Application number: 2026/91763	
What is the application for?:	Erection of 40 residential dwellings and associated works
Address of the site or building:	Land off Barnsley Road, Denby Dale, Huddersfield,
Postcode:	LS23 7BA

Type of comment: An objection	
Do you wish your comments to be published on the website anonymously?	No

I wish to object to Planning Application 2026/62/91763/E.

ANLABY - APARTMENTS

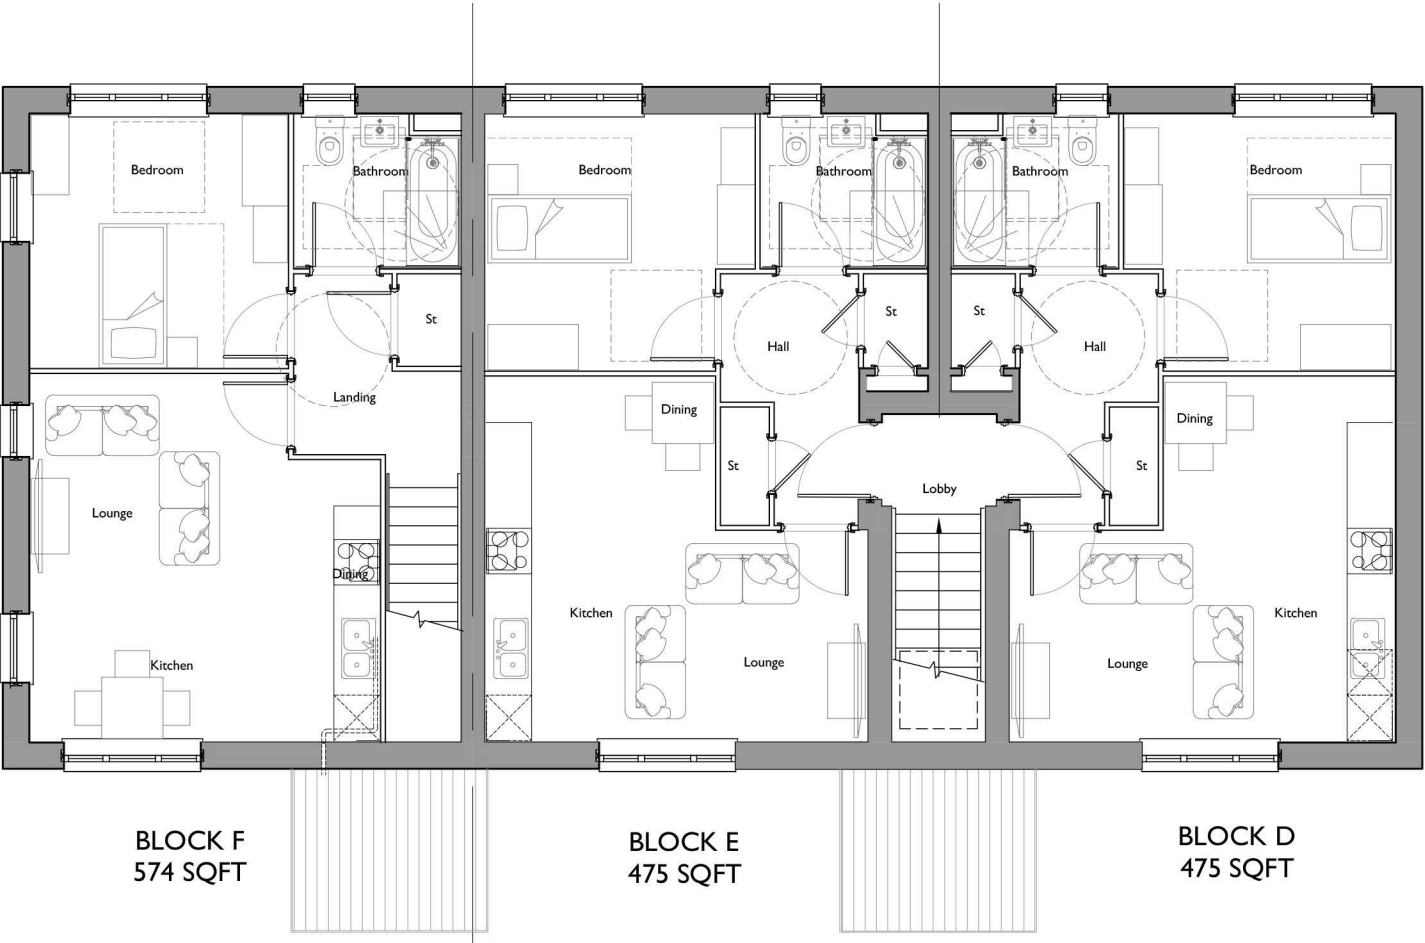
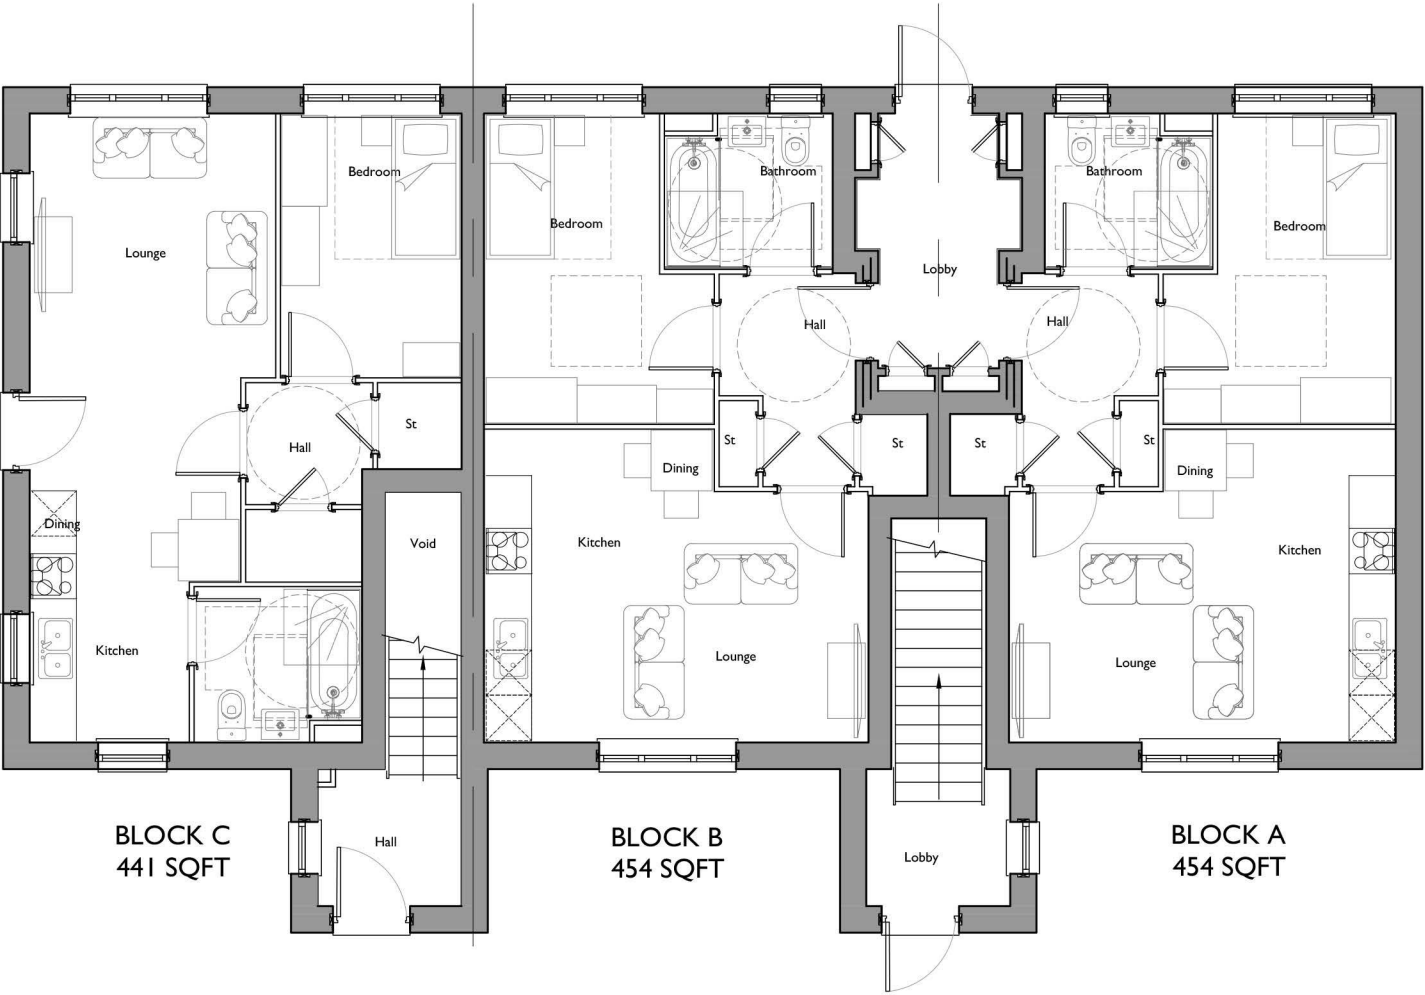
In particular, the current proposal places a two-storey apartment building containing six flats opposite our home. Previous proposals for this part of the site appeared to provide a much less intensive relationship, with an individual dwelling positioned largely side-on to the existing development.

Privacy is a particular concern. Our home has large glazed bifold doors serving the kitchen/living area, together with a private garden and balcony facing towards the application site. The proposed apartment building introduces multiple habitable-room windows opposite this aspect of our property, creating greater potential for overlooking than a side-on individual dwelling.

I therefore ask the Council to consider the position and orientation of windows, relative ground levels and actual sightlines between the proposed apartment building and the existing homes, gardens and balconies.

I am also concerned about the increased concentration of residential activity in this location, including residents, visitors, deliveries, vehicle movements and associated parking activity. I ask the Council to consider the potential for increased noise and disturbance arising from locating a six-flat apartment building directly opposite existing homes.

I respectfully ask that the siting and form of the proposed apartment building opposite the existing development, together with the overall density proposed, are reconsidered.

SITE LAYOUT PLAN - 2530-SI-02H
BARNESLEY ROAD, DENBY DALE
NEWETT HOMES
SCALE:1:500@A1 - AUGUST 2025

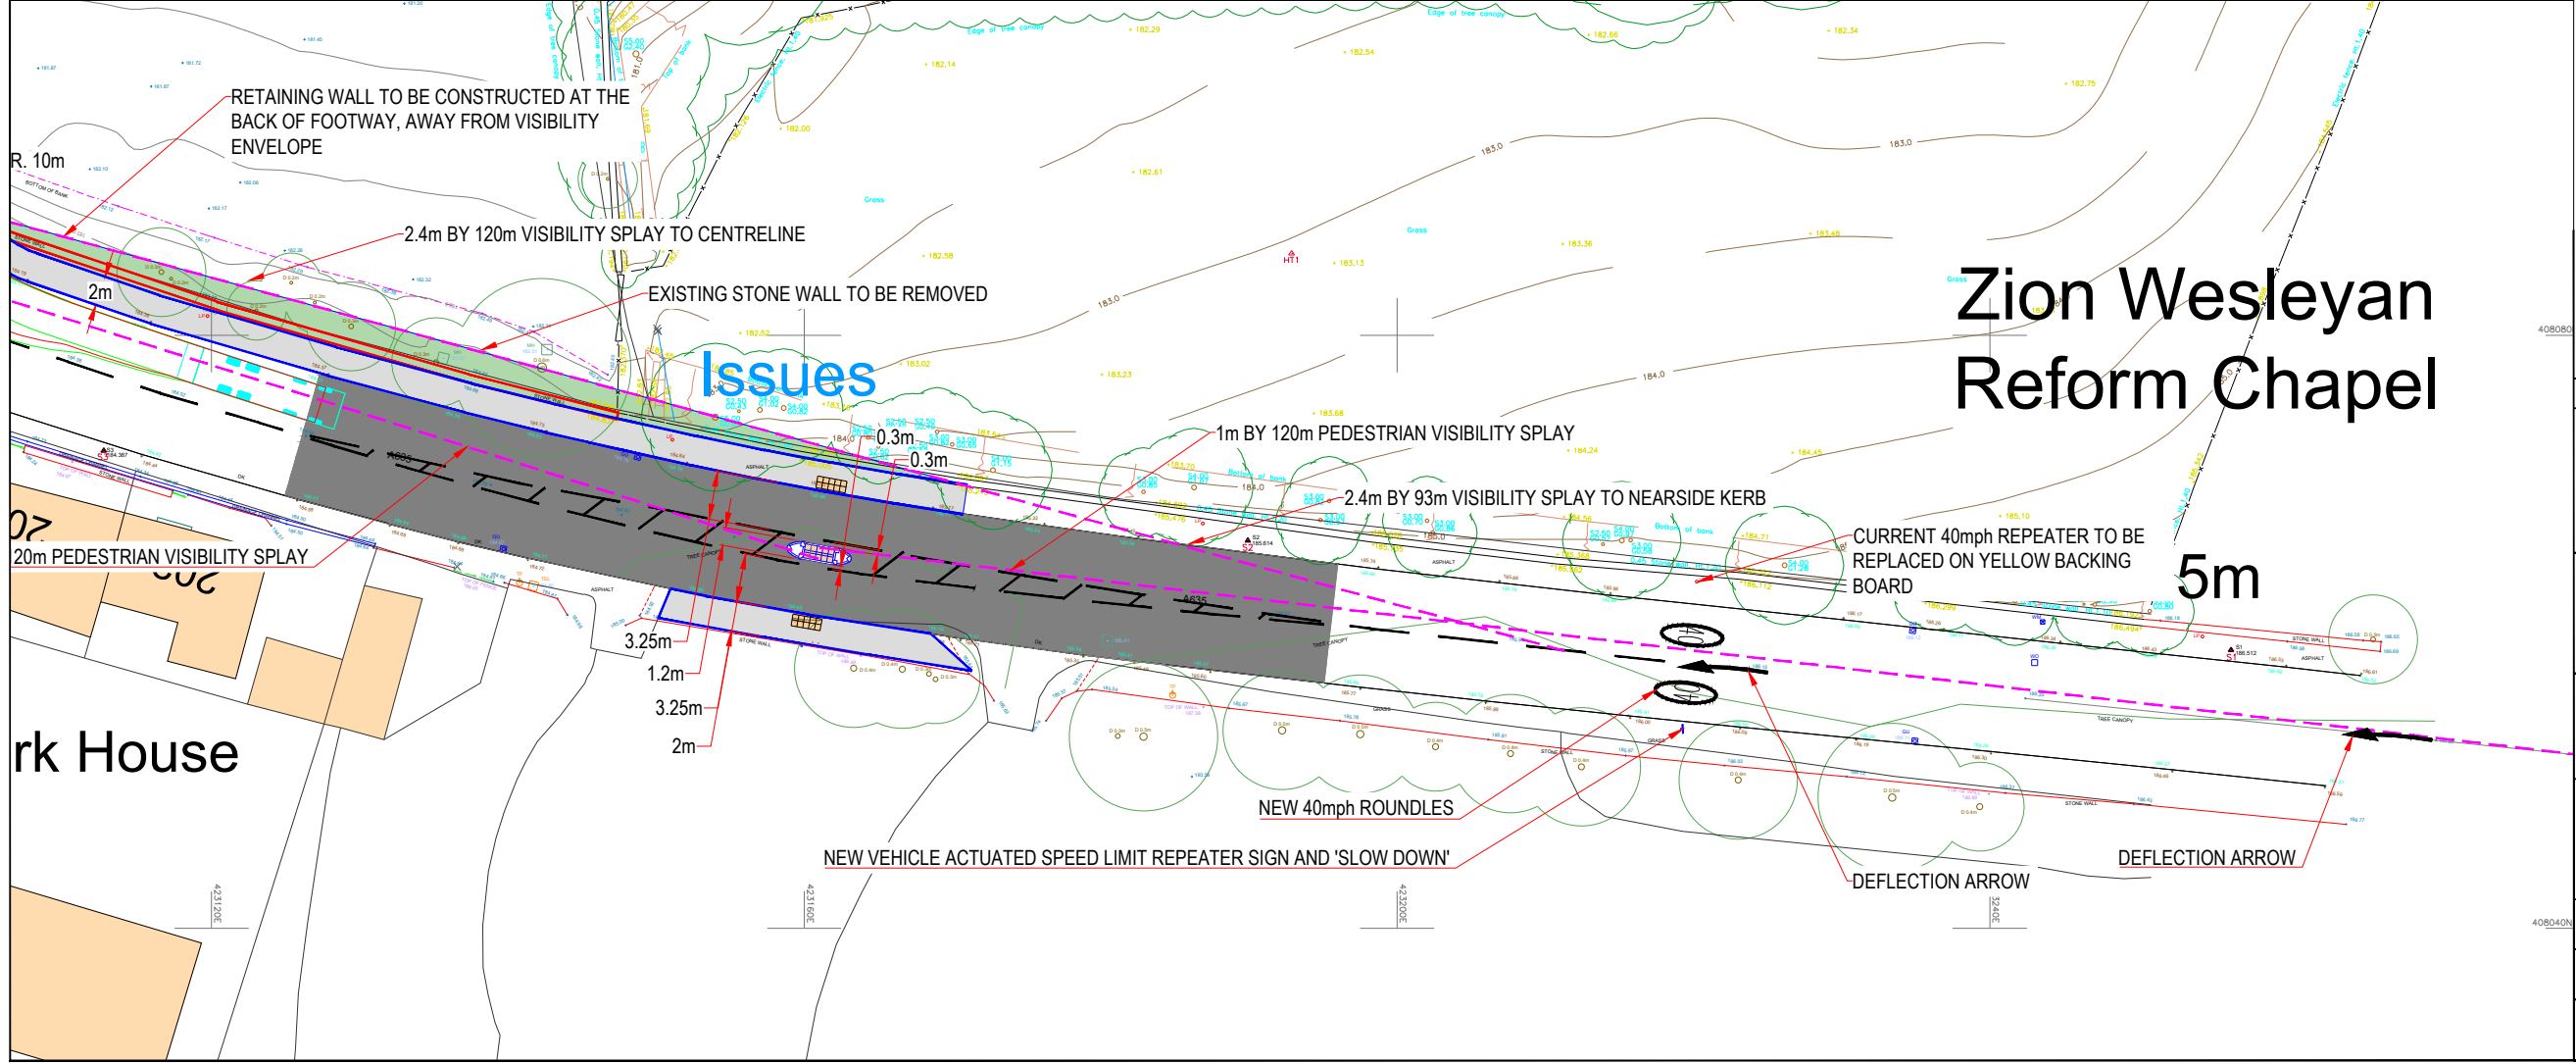
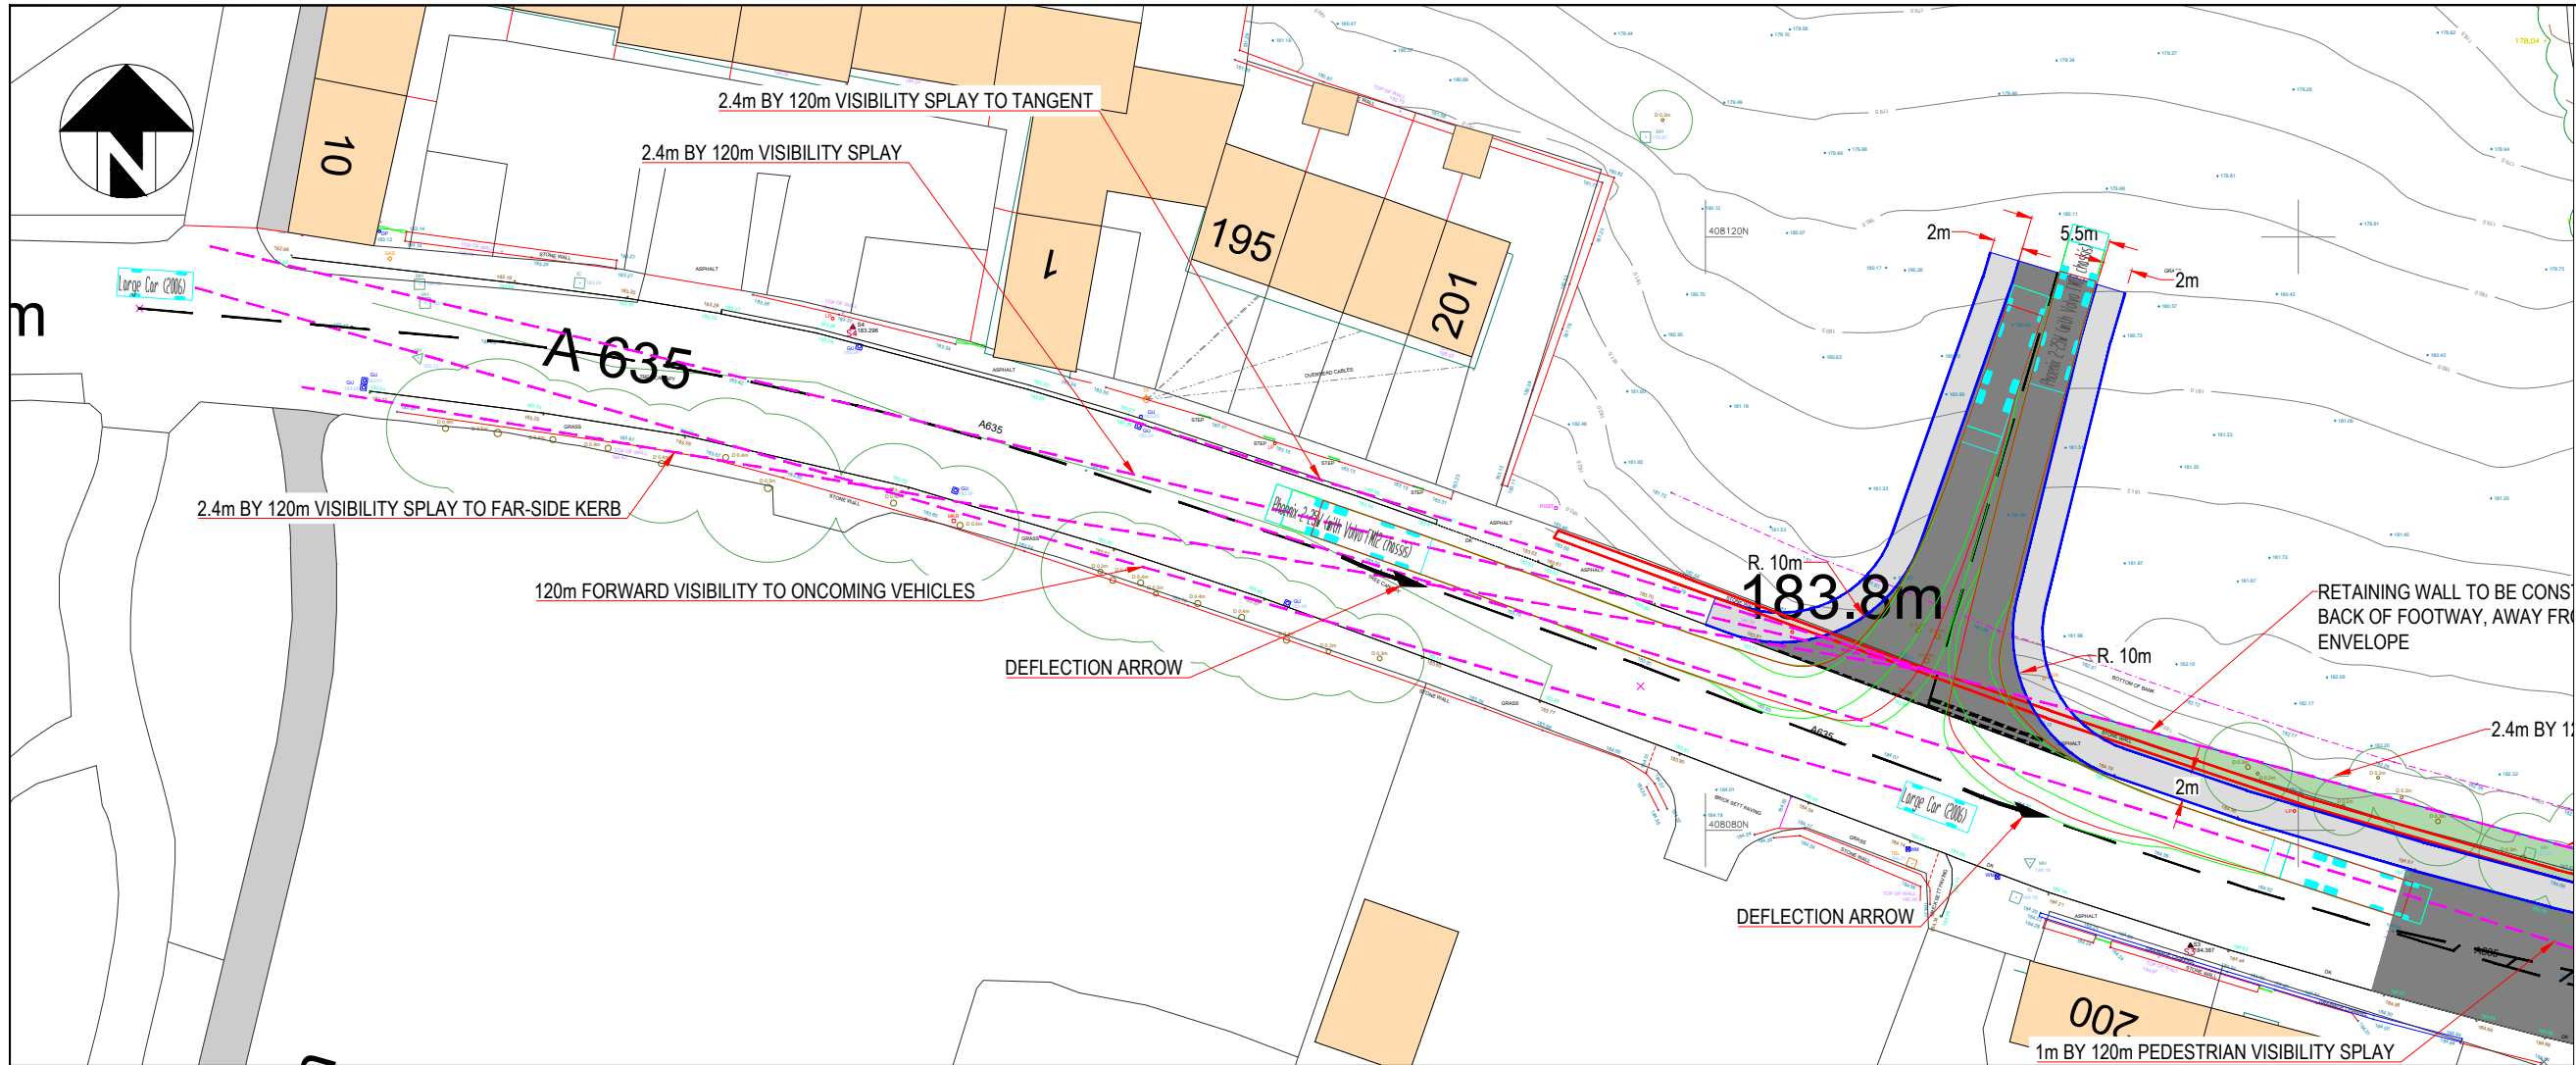
A previous scheme for this site, submitted by a different developer, provided for 30 dwellings. The current proposal seeks 40 dwellings. I am concerned that this increase in density has resulted in a more intensive relationship with the existing homes adjoining the site.

I am not objecting to residential development of the site in principle. My concern is whether increasing the scheme from the previously approved 30 dwellings to 40 has resulted in an unnecessarily intensive relationship with the neighbouring development.

I ask the Council to consider whether a layout closer in density to the previously approved scheme, and in particular a lower-density or differently orientated form of development opposite the existing homes, would provide a more appropriate relationship and better protect privacy and residential amenity.
